Applicant: Tim Higgins (Purchase/Sale Agreement)

Address: 690 6th Adams St (split from 680 Adams St)

permit # 2015-01808

CHECK-LIST AGAINST ZONING ORDINANCE

**ELEVATIONS**

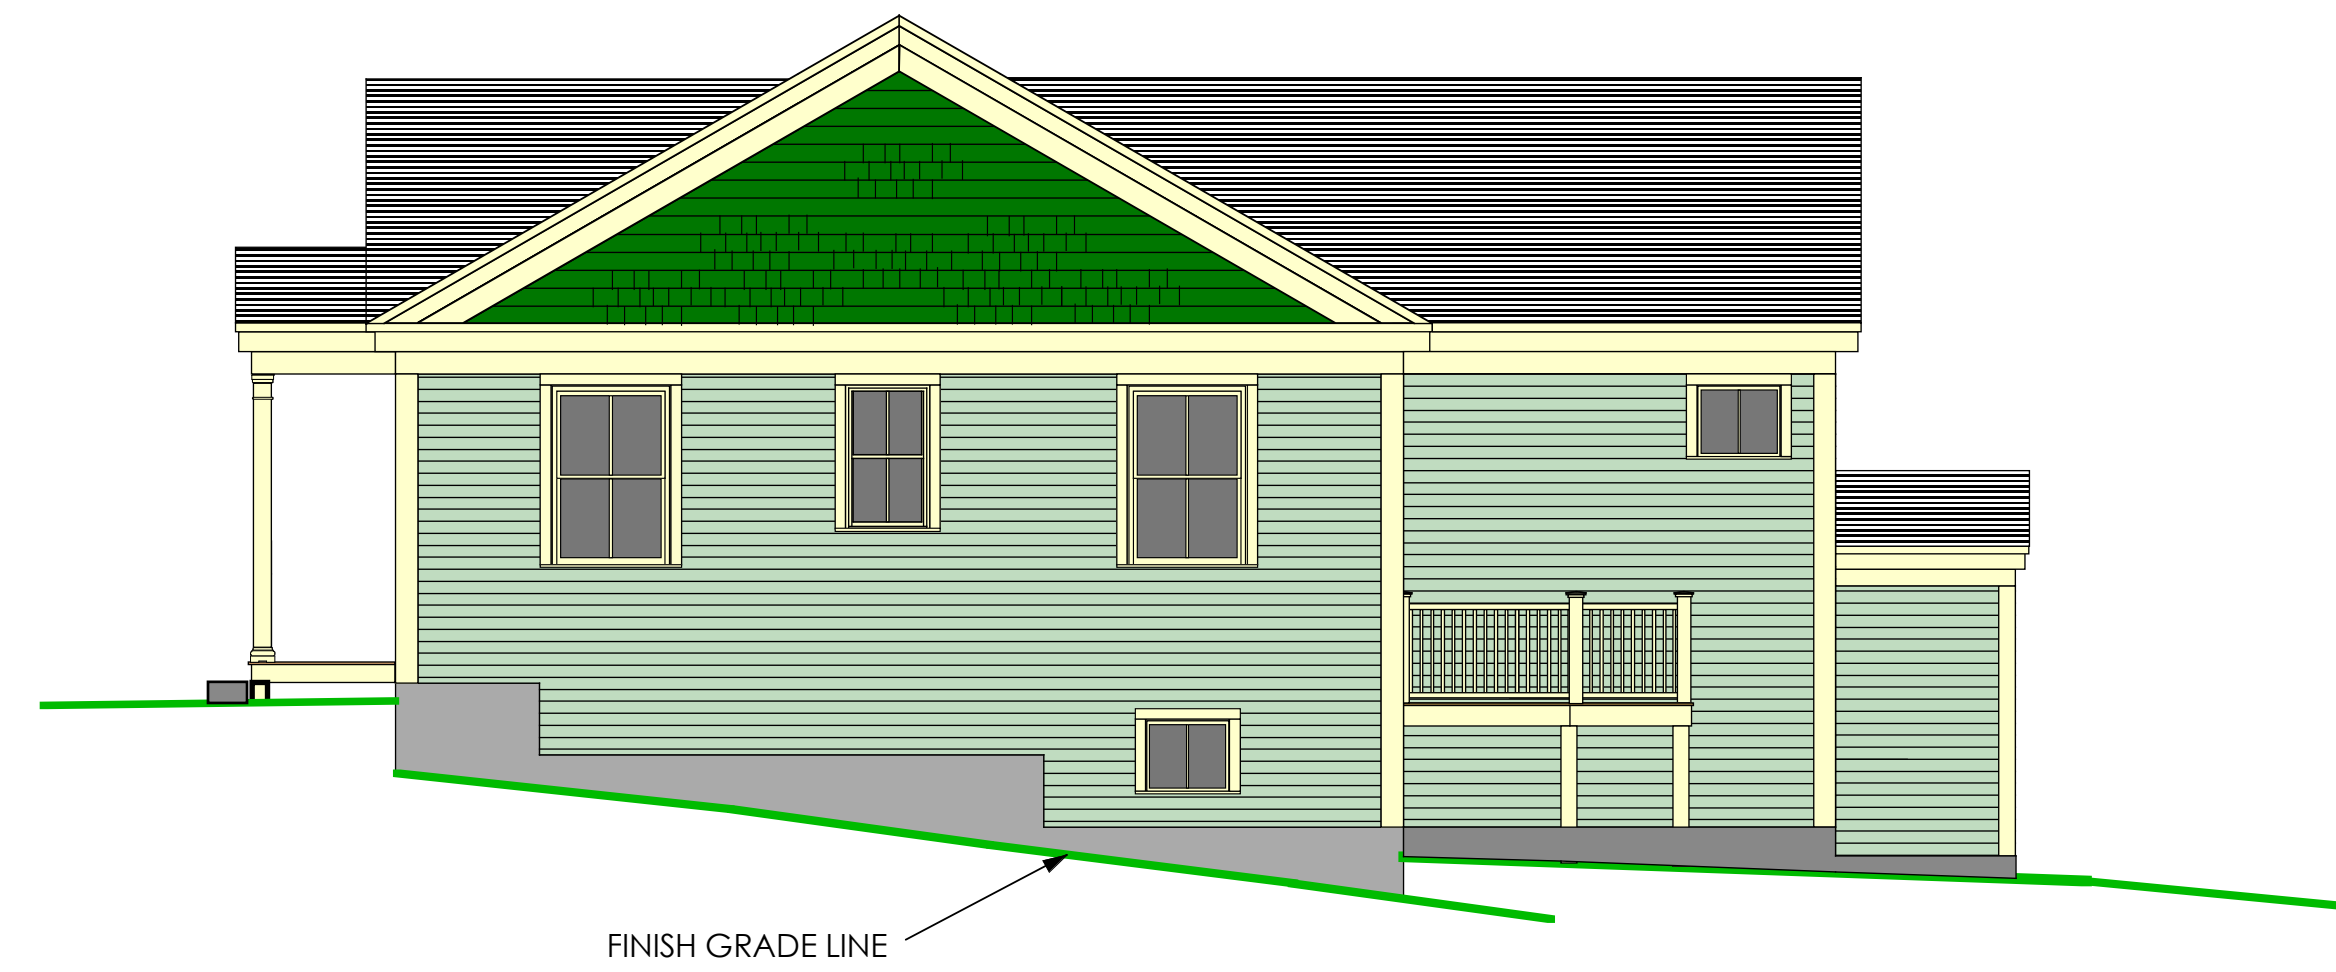
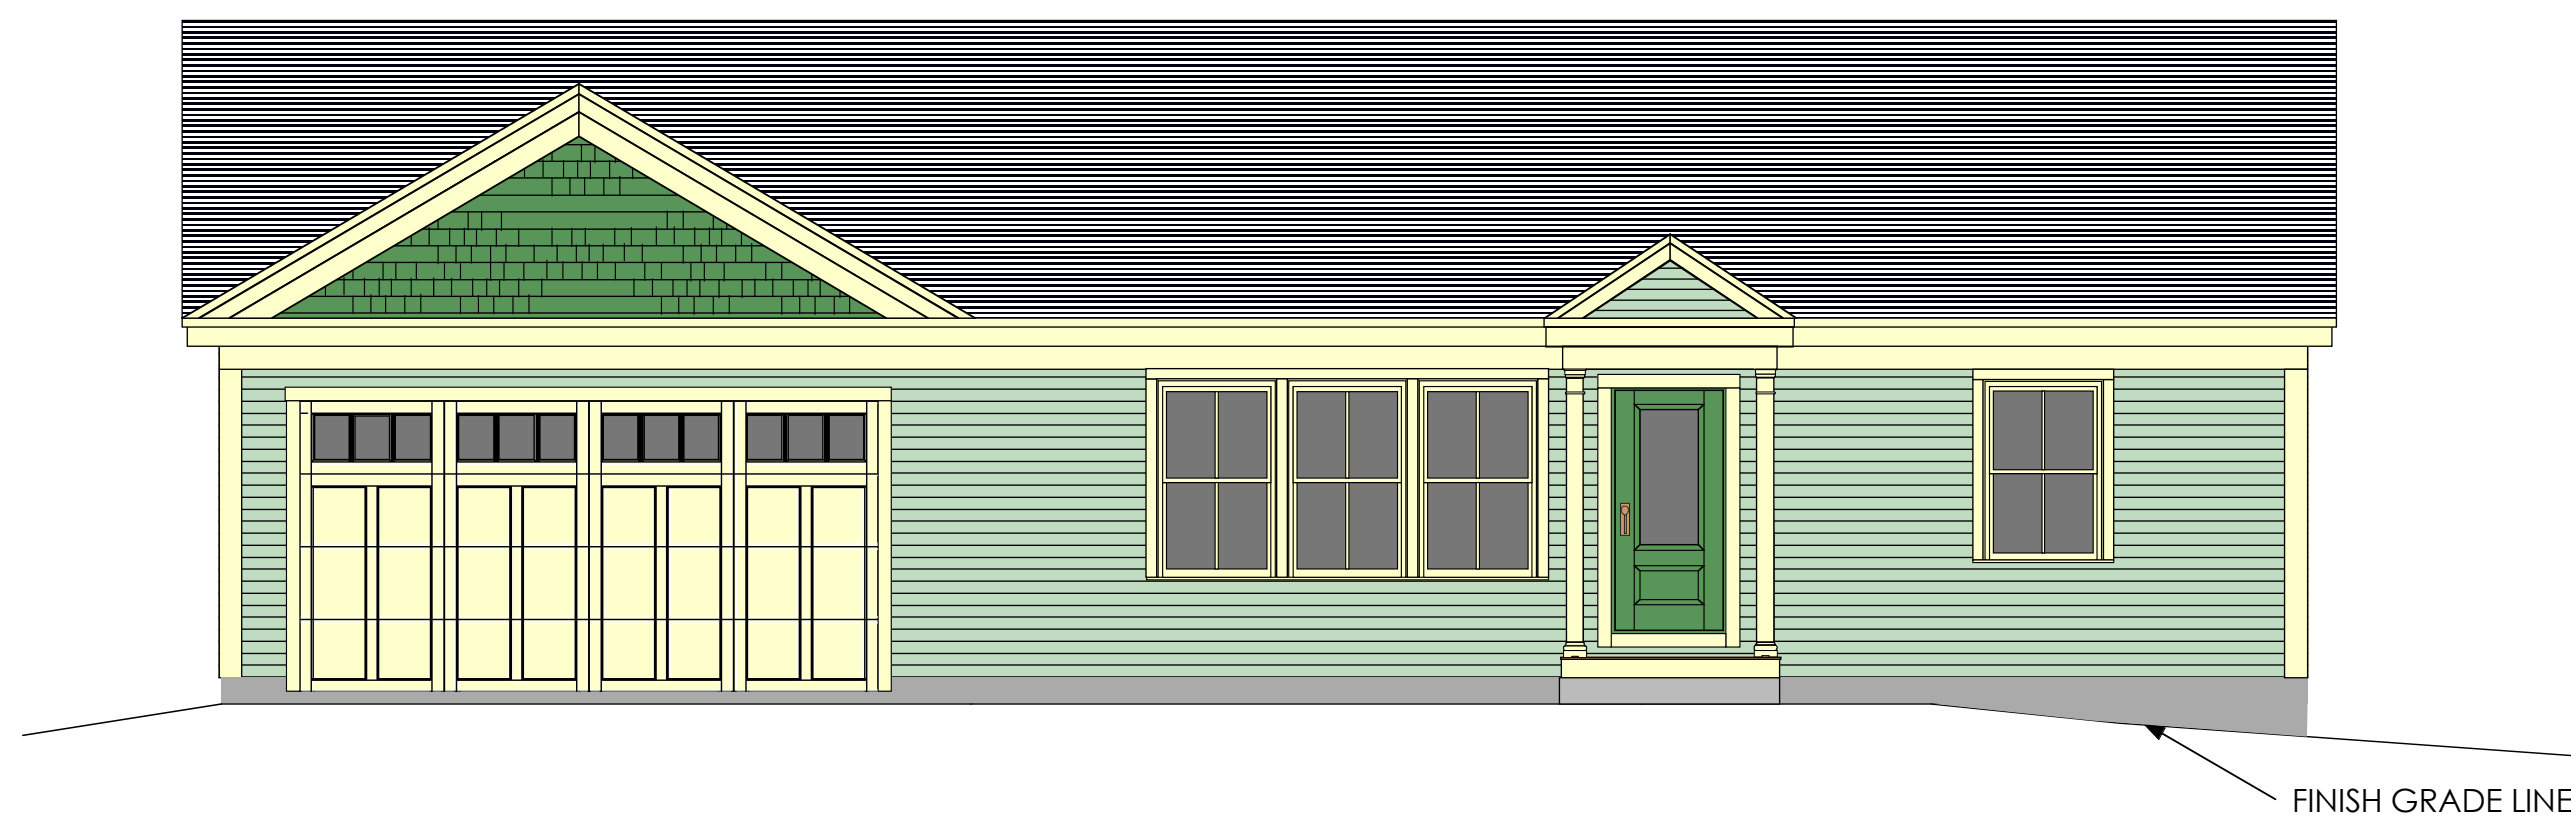
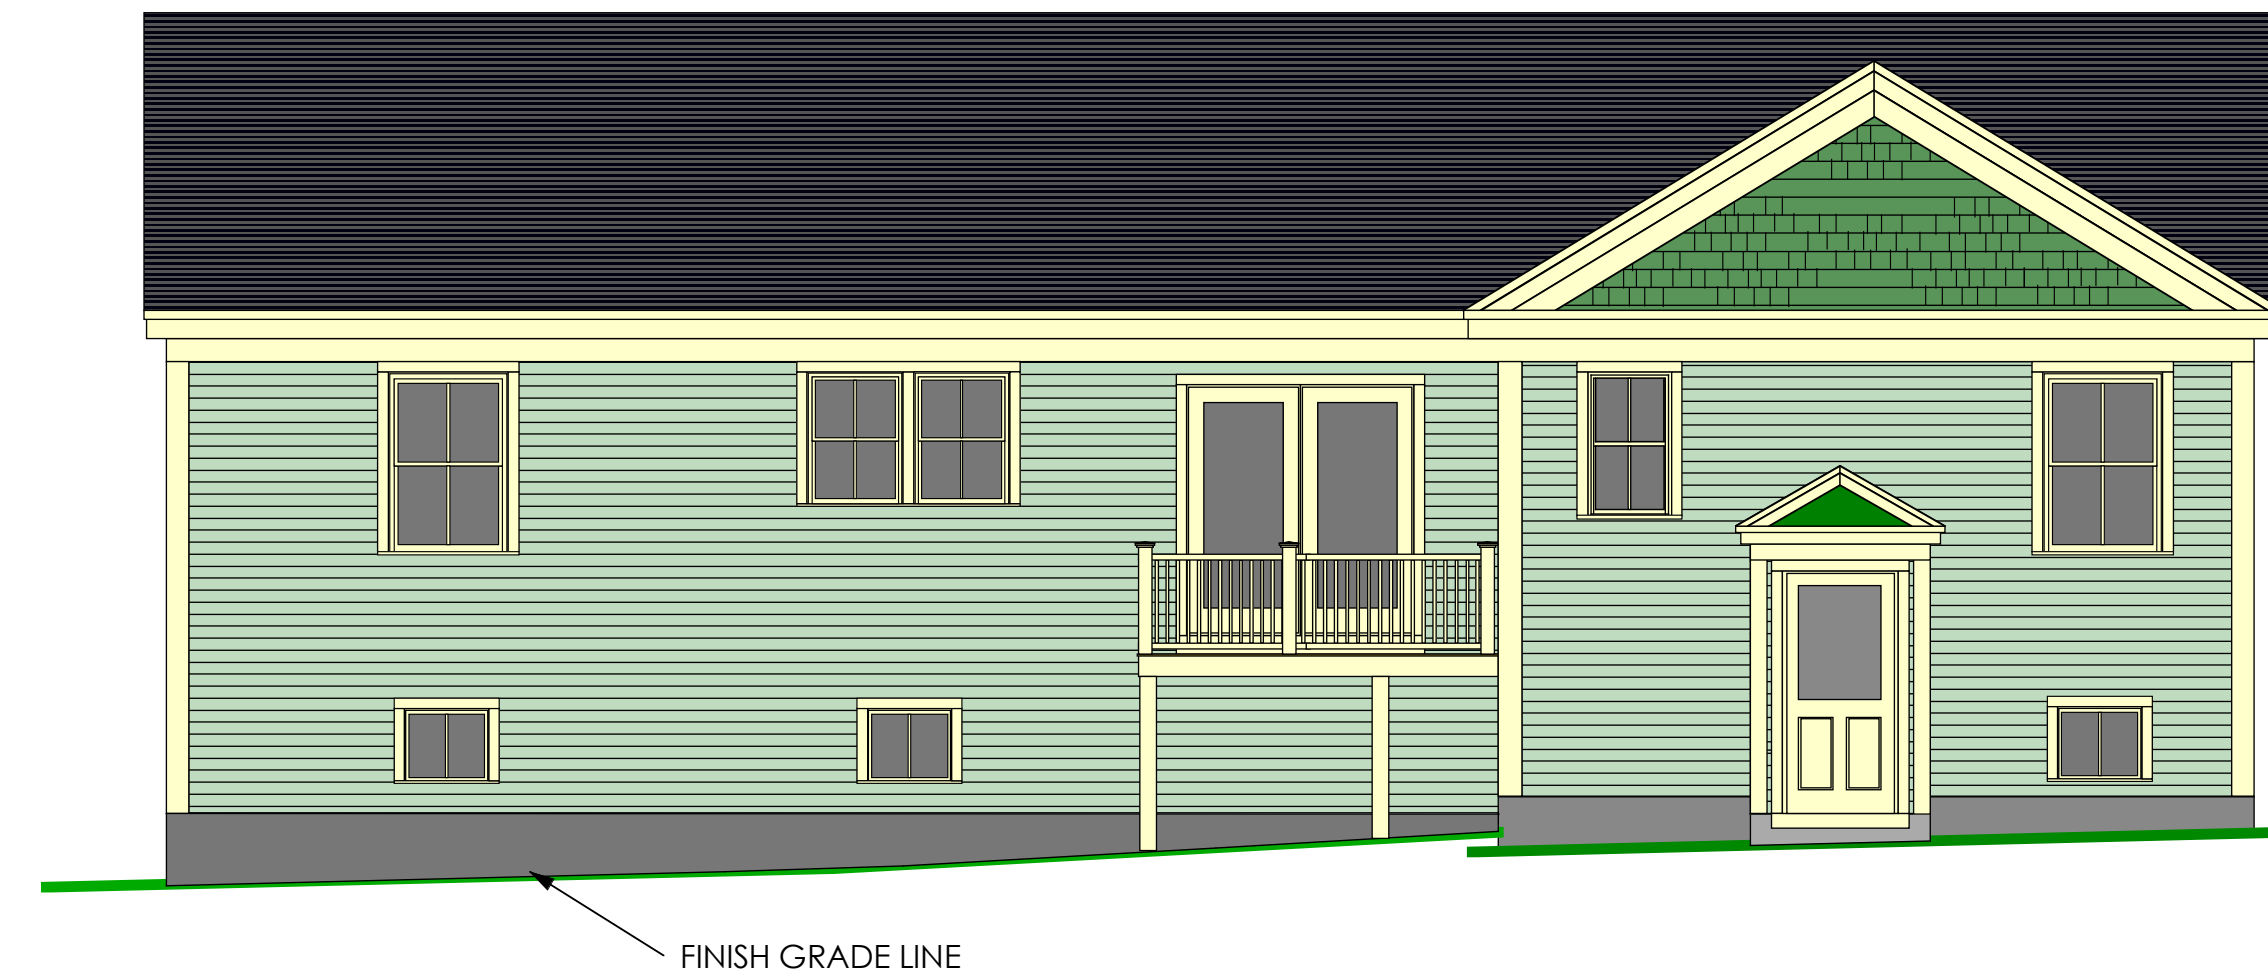
Height - 35' max - 22' to ridge from lowest grade

**SITE PLAN**  
AT  
696 AUBURN STREET, PORTLAND, MAINE  
MADE FOR  
**TIMOTHY HIGGINS**  
83 BAY STREET, PORTLAND, MAINE

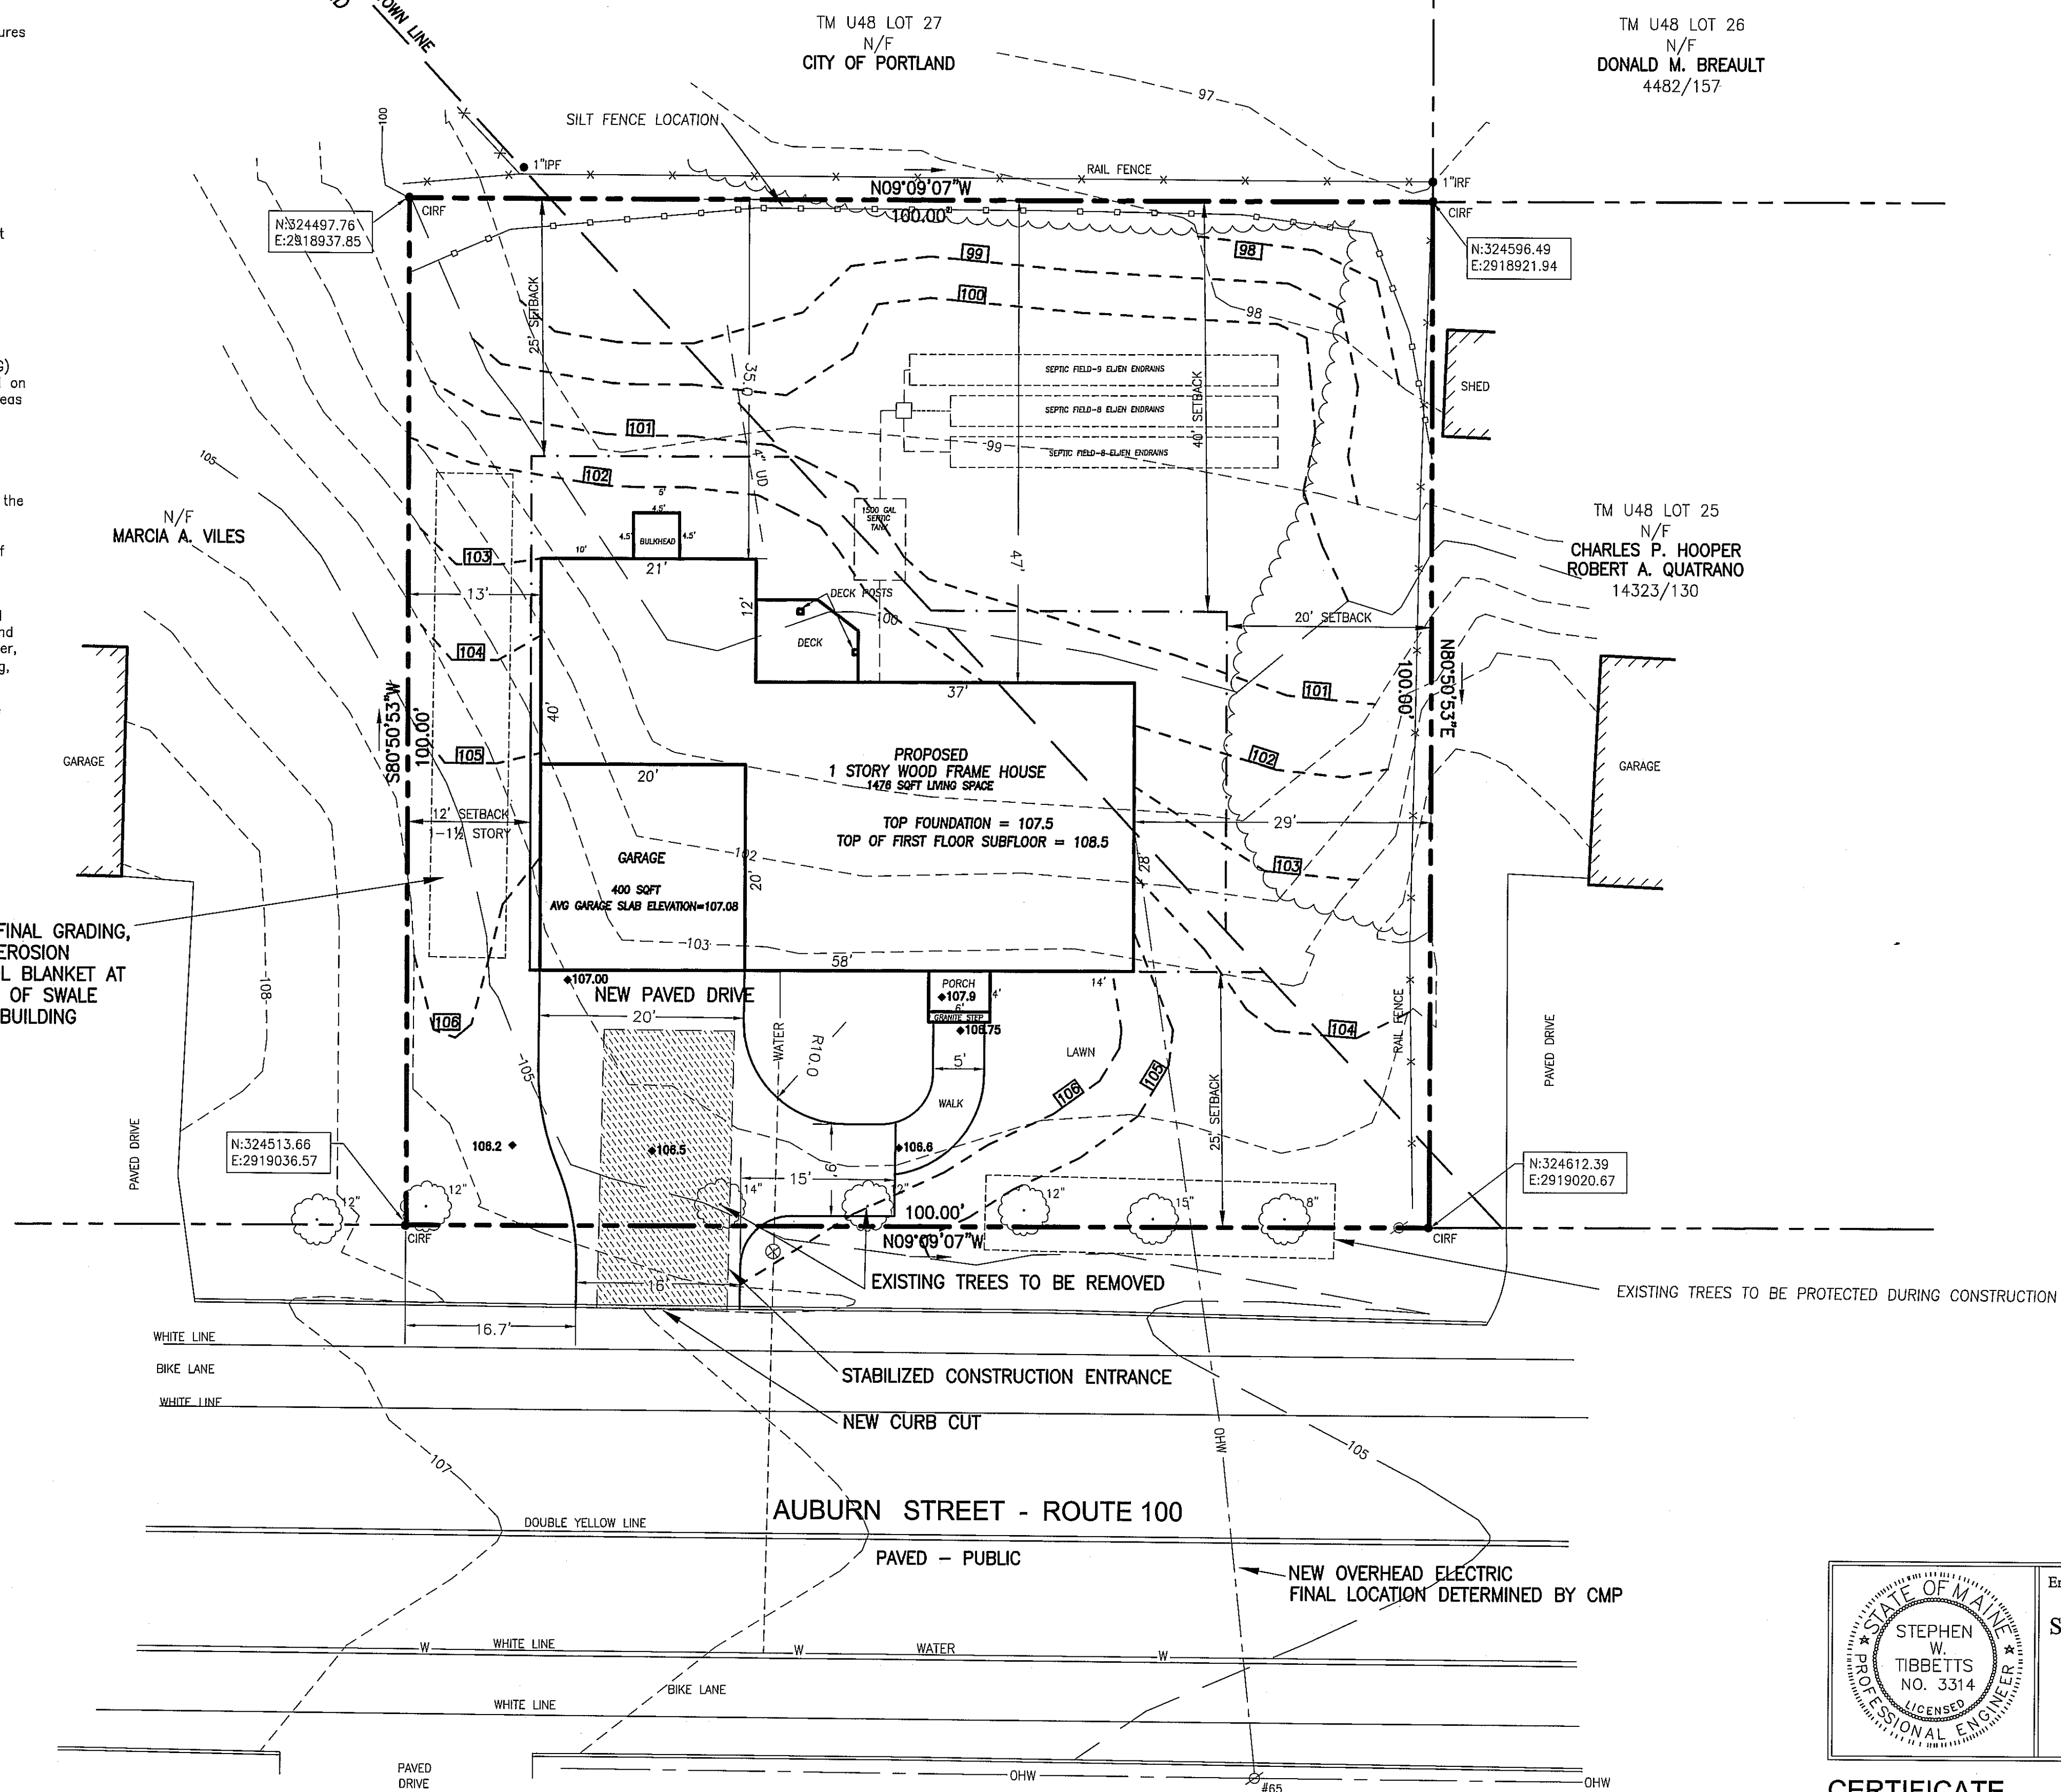
revised site plan 9/13/15

Lot Street Frontage - 50' min - 100' 5' var (OK)

Front Yard - 25' min - 25' given - front steps - encroach - OK under section 14-425 - 45' footprint - 6' off building

Rear Yard - 25' min - 28' ^{38'} setback - (OK)

Side Yard - ^{1 1/2' var - not suitable} two story - 14' min - 13' on left - 26' on right - OK - if two stories need lot of 28' - has 34'

Lot Area - 10,000 sq ft min - 10,000 sq ft given (OK)

Lot Coverage/ Impervious Surface - 20% = 2,000 sq ft

Off-street Parking - 2 spaces - 2 car garage provided - 20' x 22'
